Recommendation Report for Works to Tree(s) on trees subject to a Tree Preservation Order (TPO)

REF NO: AW/281/18/T

LOCATION: 25 Rucrofts Close
Aldwick Fields
PO21 3SL

PROPOSAL: Crown reduction of 3m to 1 No. Lombardy Poplar tree & Crown thin of 10% to 1 No. Horse Chesnut tree.

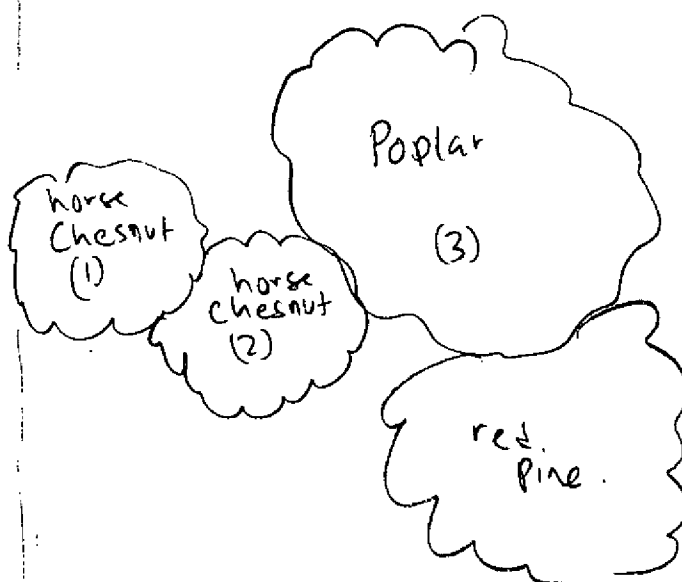
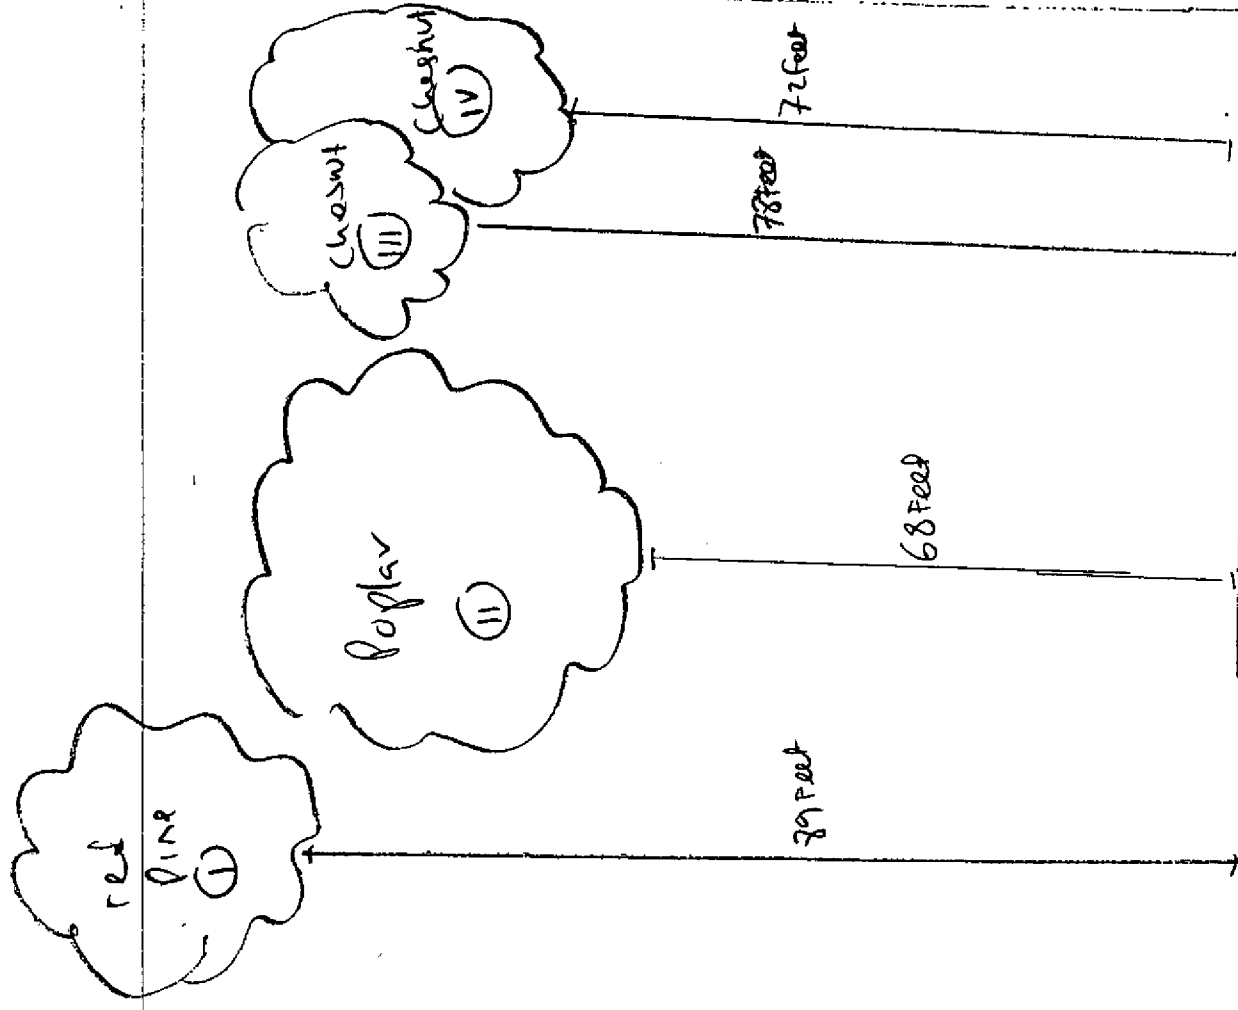
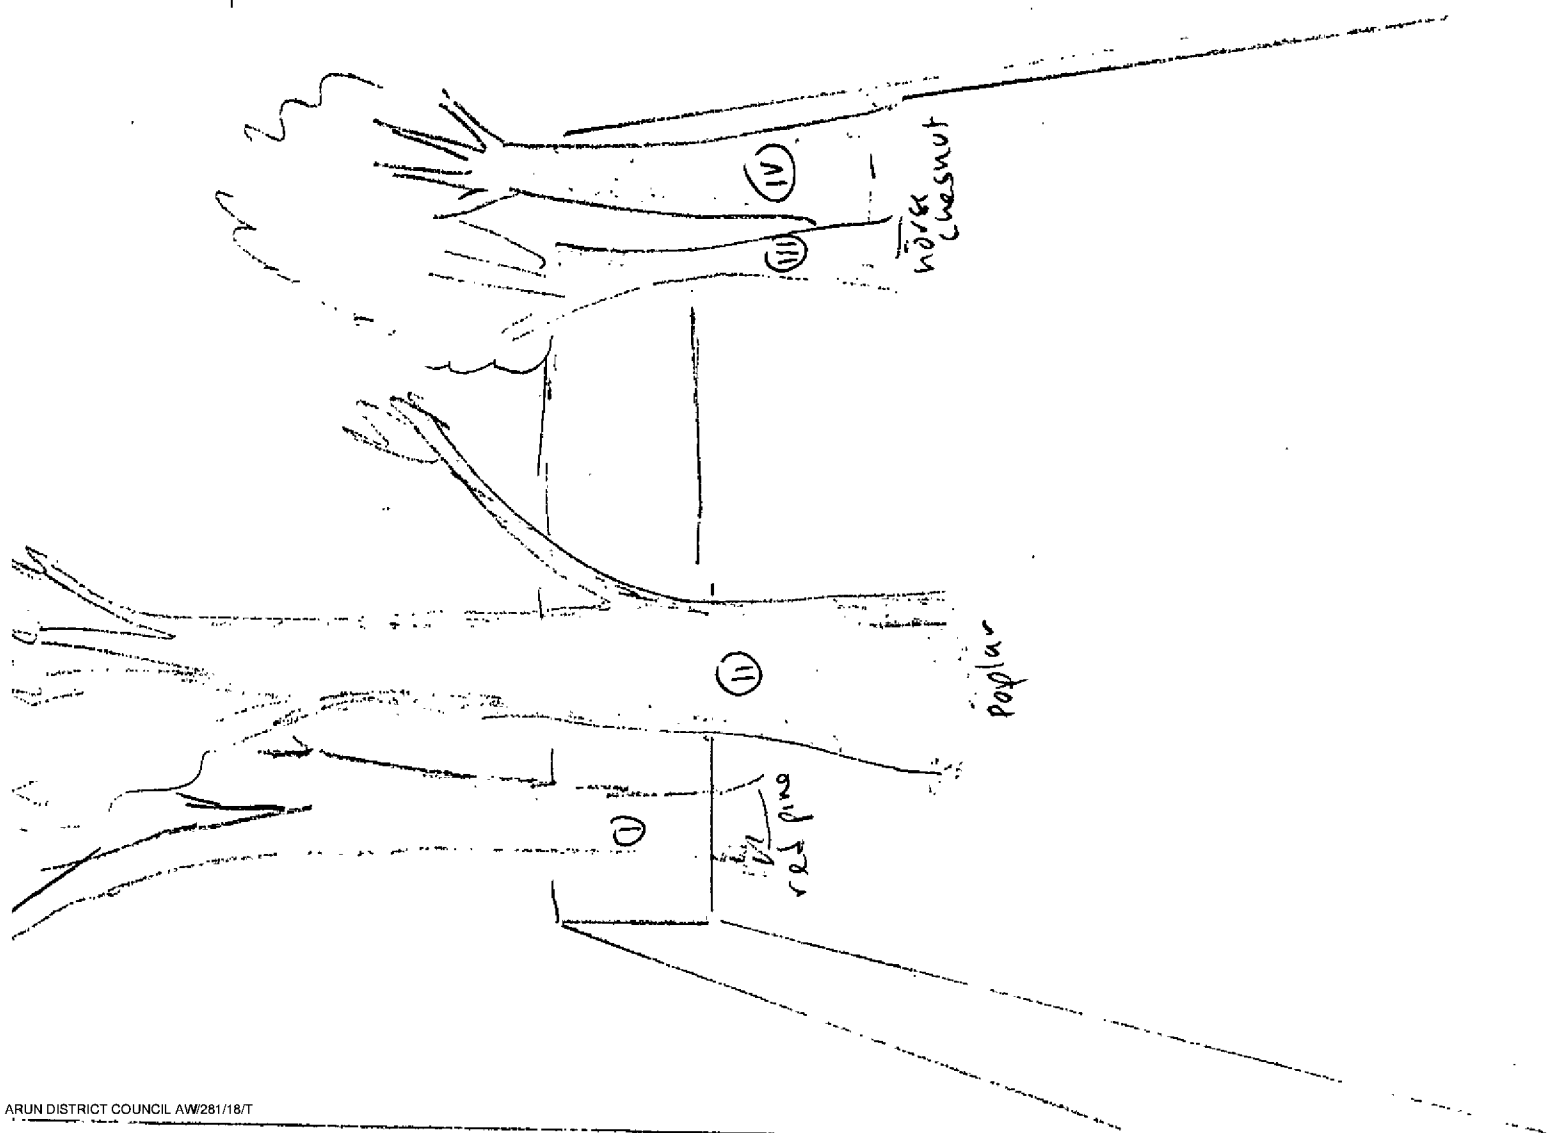
·T1/2 Actually a twin-stemmed individual tree, in apparent fair condition although slightly suppressed by larger companion trees and consequently of drawn-up form.

·Crown thinning is sought primarily to attend to crossing/weak branches.

·T3 appears to be in a fine physiological state. It has multiple low stem unions at different heights. Tall and leggy scaffold limbs will no doubt oscillate alarmingly during episodes of exposure to high wind speed although clearly it has endured to date.

·T3 - The long-term vitality of this tree is best respected when significant pruning work such as proposed, is undertaken during either the summer (mid-June to mid-September) or mid-winter (mid-December to mid-February) periods. Ideally, the work proposed should only be undertaken during these periods.

·Where whole branches are to be removed and final cuts made close to the trunk or branch union they are to be made as shown in Figure 2 of BS3998:2010

·Where branches are to be shortened back the final cuts are to be made at the correct angle own in BS3998:2010 and adjacent to a live bud or lateral.
